Arun District Council
Arun Civic Centre
Maltravers Road
Littlehampton
West Sussex BN17 5LF
Planning & Building Control General Enquiries
Tel: (01903) 737756 Fax: (01903) 730442
Dx: 57406 Littlehampton
Minicom: 01903 732765
e-mail: planning@arun.gov.uk
website: www.arun.gov.uk/planning

Application No: A/26/21/RES
Site Address: Land west of Brook Lane and South of A259 Angmering BN16 3JL
Description of works: Approval of reserved matters following outline consent A/44/17/OUT for appearance, landscaping, layout & scale for the demolition of existing buildings on site & erection of a mixed use development comprising of 90 No. residential dwellings & a care home & ancillary facilities including railway crossing together with associated access, car parking & landscaping. This application also lies within the parishes of Rustington & Littlehampton.

Thank you for your internet representation made on 15th March 2021 which has been recorded as an objection with the comments as follows:

2. Site Analysis
Site Access / Connectivity

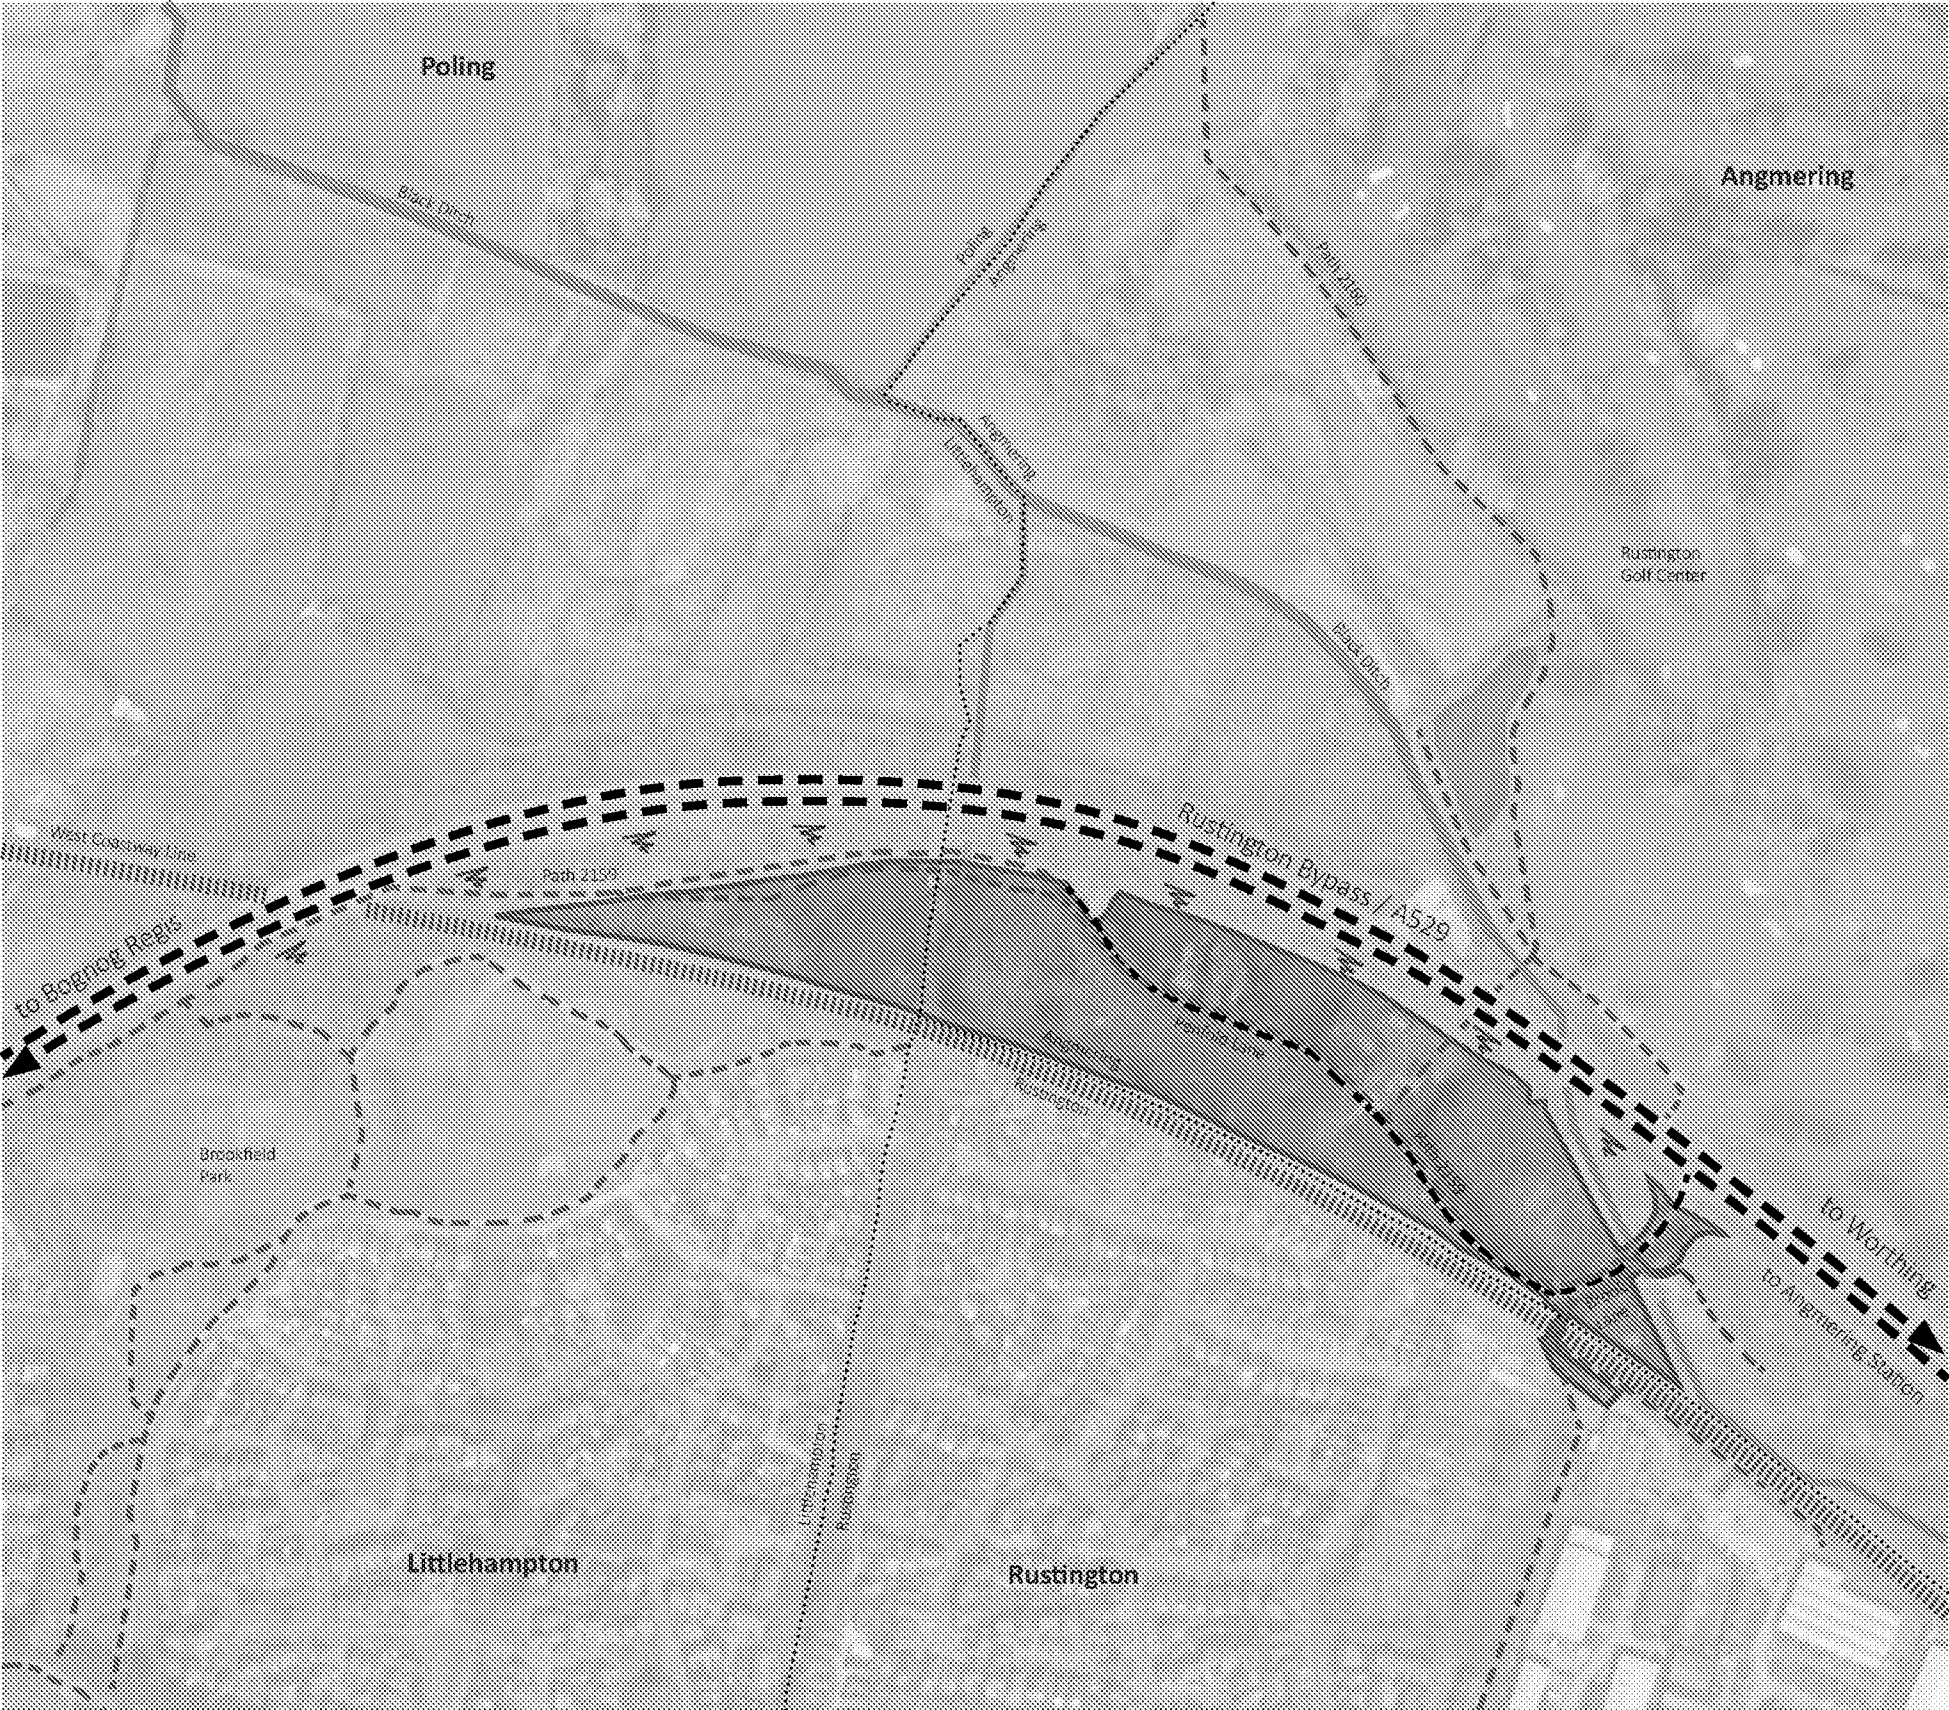
This is an objection on behalf of Sustrans and the Bognor Regis Cycle Forum. There seems to be no attempt to provide any active travel connections. Whilst the developers state that cycle parking is to be provided, for the houses, these are all to the rear of the properties. There is no attempt to provide safe cycling routes, nor any connection to the wider cycle network such as National Cycle Route 2. The pedestrian bridge over the railway line should be amended to be a shared use bridge, to then allow cyclists safe connections to the south, and avoid a large detour using the spine road.
